KIRKLEES METROPOLITAN COUNCIL INVESTMENT & REGENERATION SERVICE

DELEGATED DECISION TO DETERMINE PLANNING APPLICATIONS

Reference No:	2026/62/90619/W
Site Address:	United Church Marsden, Warehouse Hill Road, Marsden, Huddersfield, HD7 6AB
Description:	Change of use and alterations to church (class F1) and Sunday school to form 8 residential units (class C3), including internal reconfiguration and external alterations, insertion of rooflights and formation of roof terrace, associated parking, landscaping and ancillary work. (within a Conservation Area)
Recommending Officer:	Danielle Cooper

Officer Report – 2026/90619

Proposed Second Floor Plan
Scale 1:100

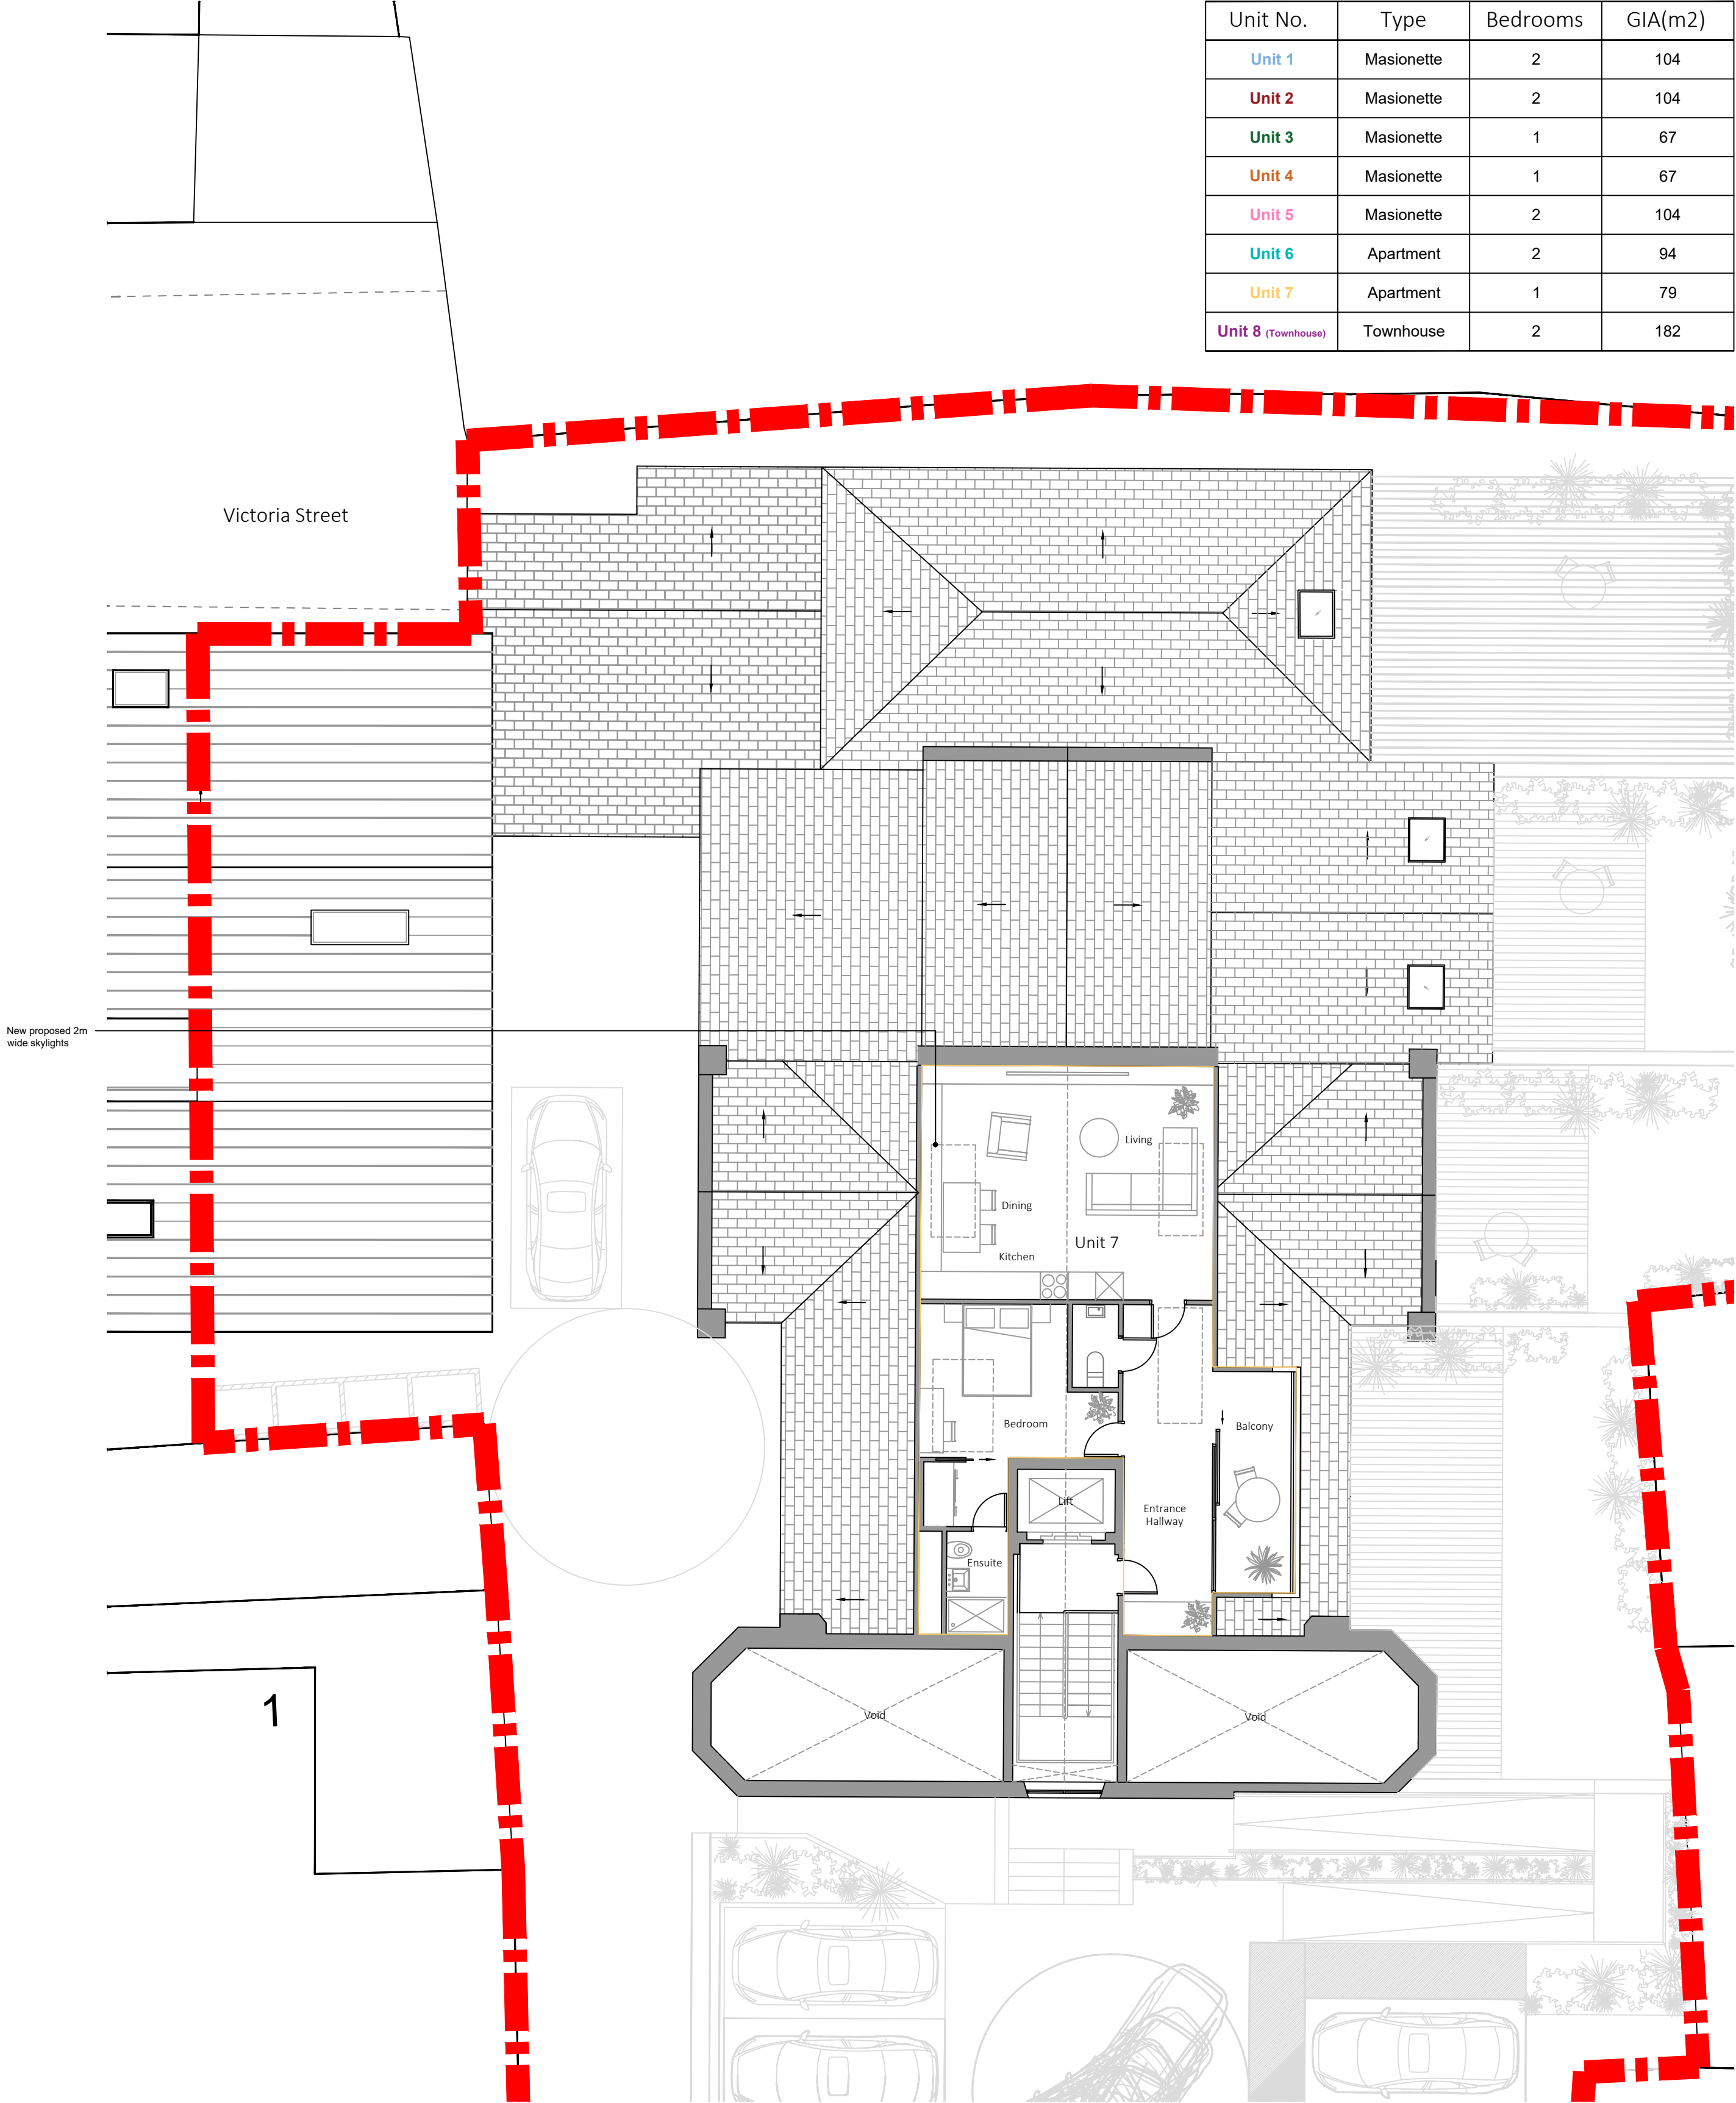
The proposed recessed balcony with a screen to the east side elevation is considered to be of a large addition within the roofscape. However, as a result of its position and design, it will not be highly visible from the public realm and as such is not considered to result in any adverse visual harm to the character and appearance of the building or conservation area. Full details and section of the proposed recessed balcony and balustrade will be conditioned to be submitted prior to commencement to ensure the visual amenity of the building is protected.

title:
Proposed Elevations A & B
(United Church)

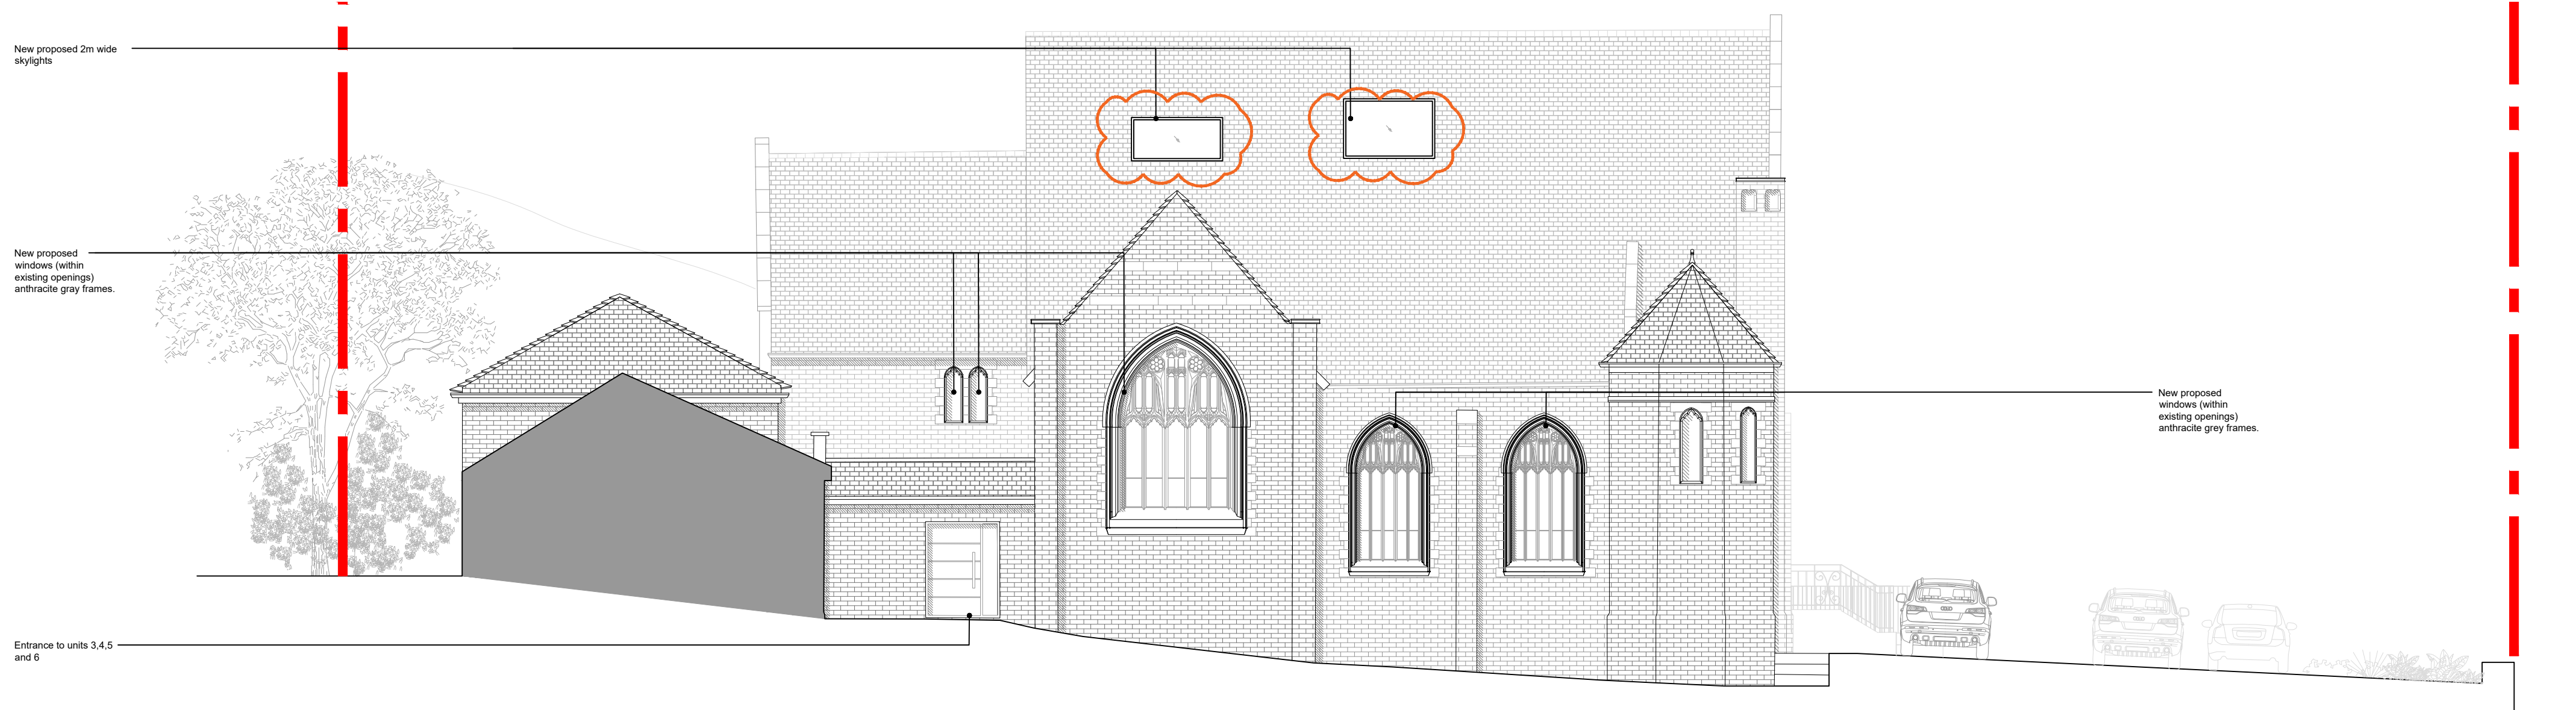
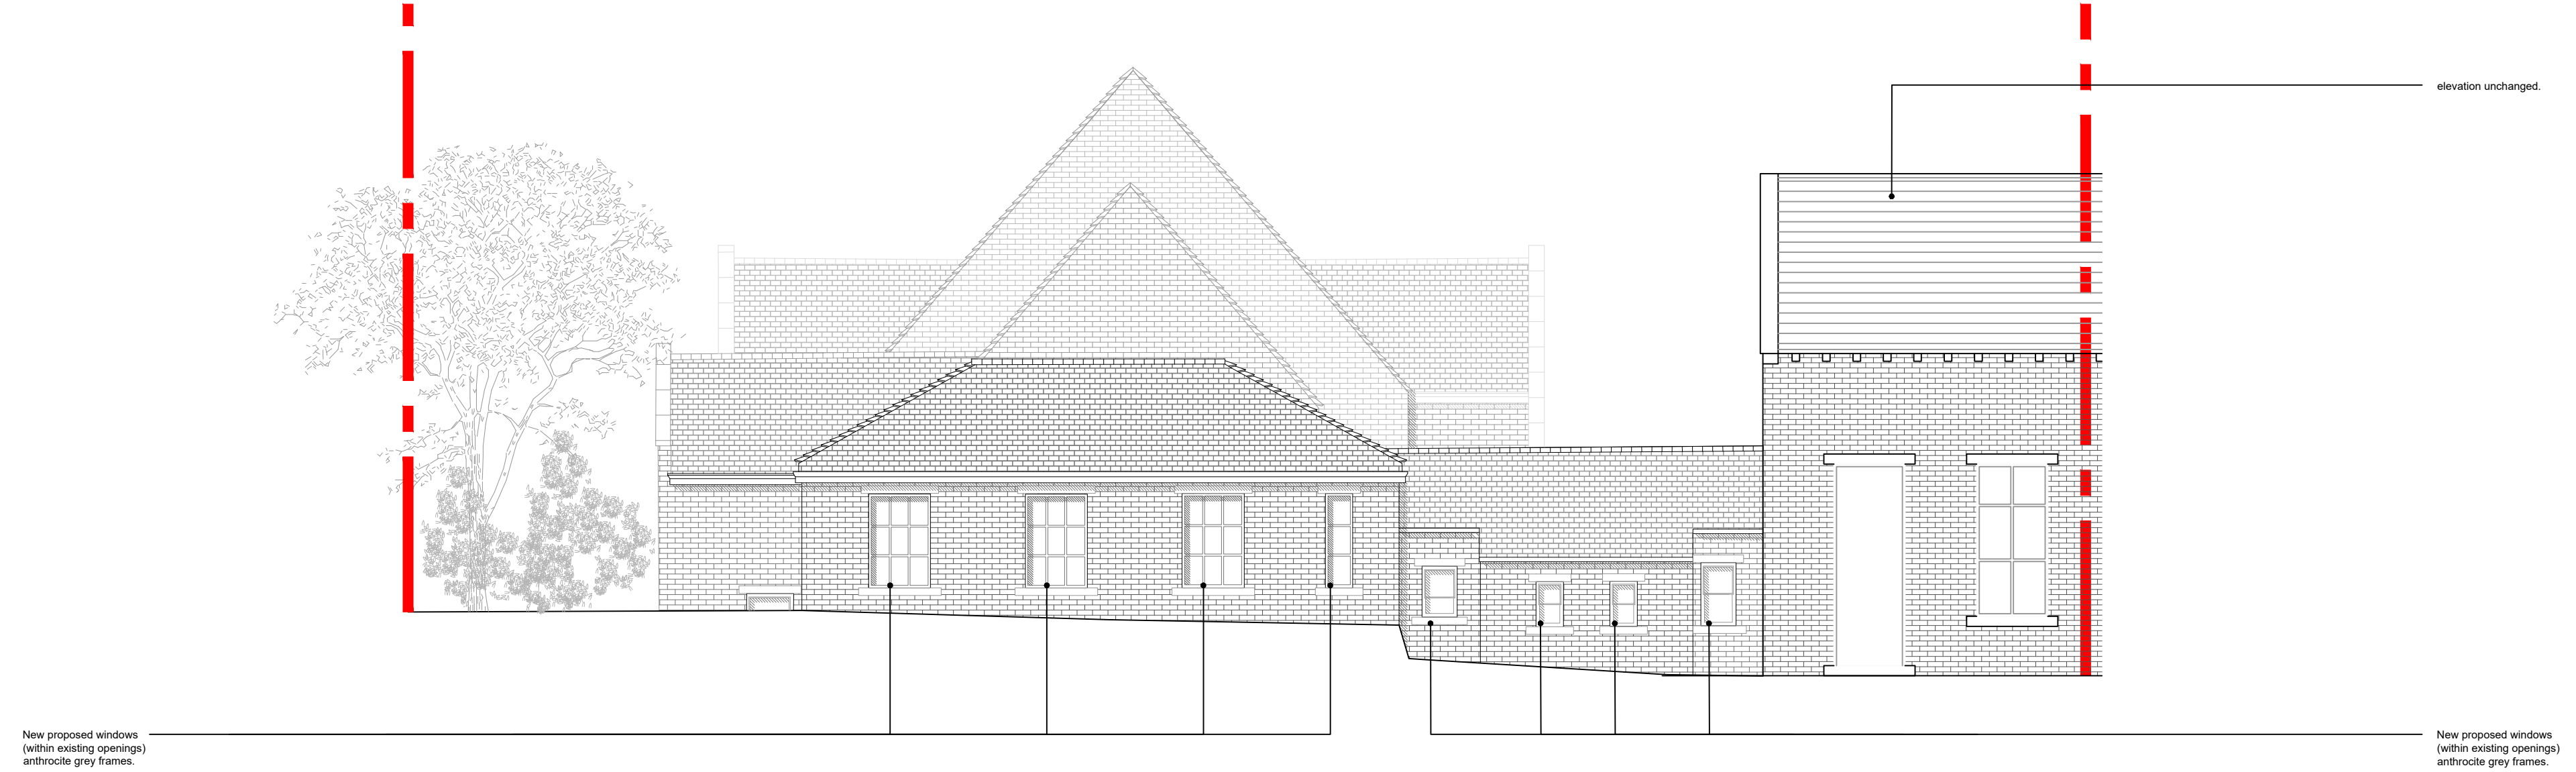
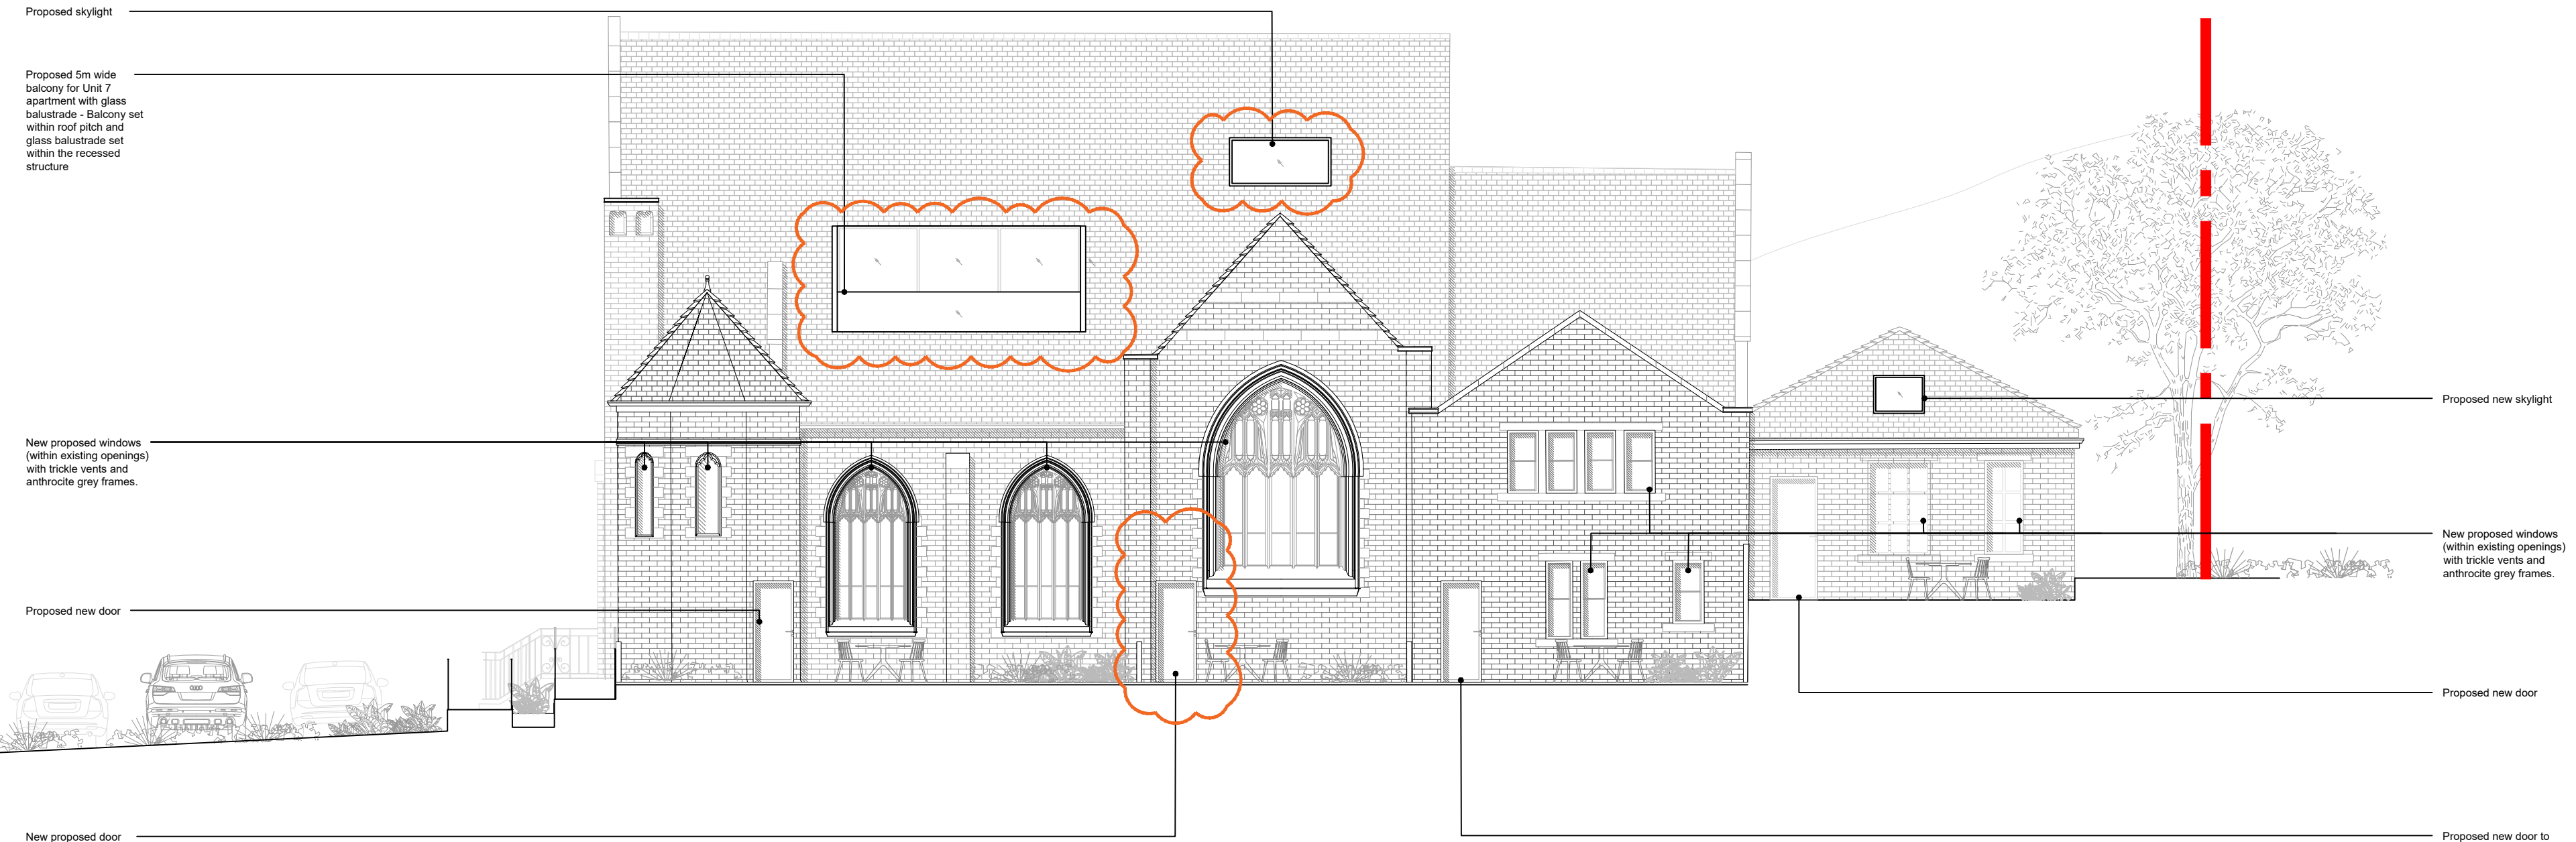
The large front window and two of the smaller front windows which are stained glass will be retained which is welcomed by the local planning authority as it ensures the historic character of the building is protected.

The other stained windows on the building will be replaced. Conservation and Design noted that to protect visual amenity, it is important to retain the original

stone tracery and stained-glass windows as they make a positive contribution to the character of the non-designated heritage asset and the conservation area. As such, the agent has proposed that they will retain the original stone tracery, encapsulate and reuse the stained glass within the lower section of the windows, and introduce a limited amount of clear glazing at the upper level for natural light and selected upper sections to be openable to provide the necessary ventilation. Conservation and Design have confirmed they are satisfied with this approach, as it will protect some of the historic fabric of the building. A condition will be imposed to ensure full details, sections, materials and methods of encapsulation of all replacement windows are submitted prior to commencement of these works. This is to ensure visual amenity of the building is protected.

The proposed stained-glass windows on the front and side elevations will be retained at the lower level, with clear glazing introduced to the upper sections. This design approach will help to limit any potential overlooking of neighbouring properties. Consequently, it is not considered that the side windows will result in an unacceptable loss of privacy to the rear gardens of the neighbouring properties to the east.

While the proposed side windows without stained glass will allow some views towards the rear garden areas of the neighbouring properties to the east, they will not provide direct views into their immediate private amenity spaces. As such, the degree of overlooking is not considered to be significant and would not justify the refusal of the application on privacy grounds. In addition to this, the proposed recessed balcony will provide views towards the rear of No. 1 Warehouse Road Hill. To mitigate the impact of overlooking, the agent has submitted a revised elevation plan to show the balcony to have a 1.7m screen. A condition will be imposed to ensure the full details of the balustrade is submitted to the local planning authority to protect the residential amenity of No. 1 Warehouse Road Hill rear amenity space.
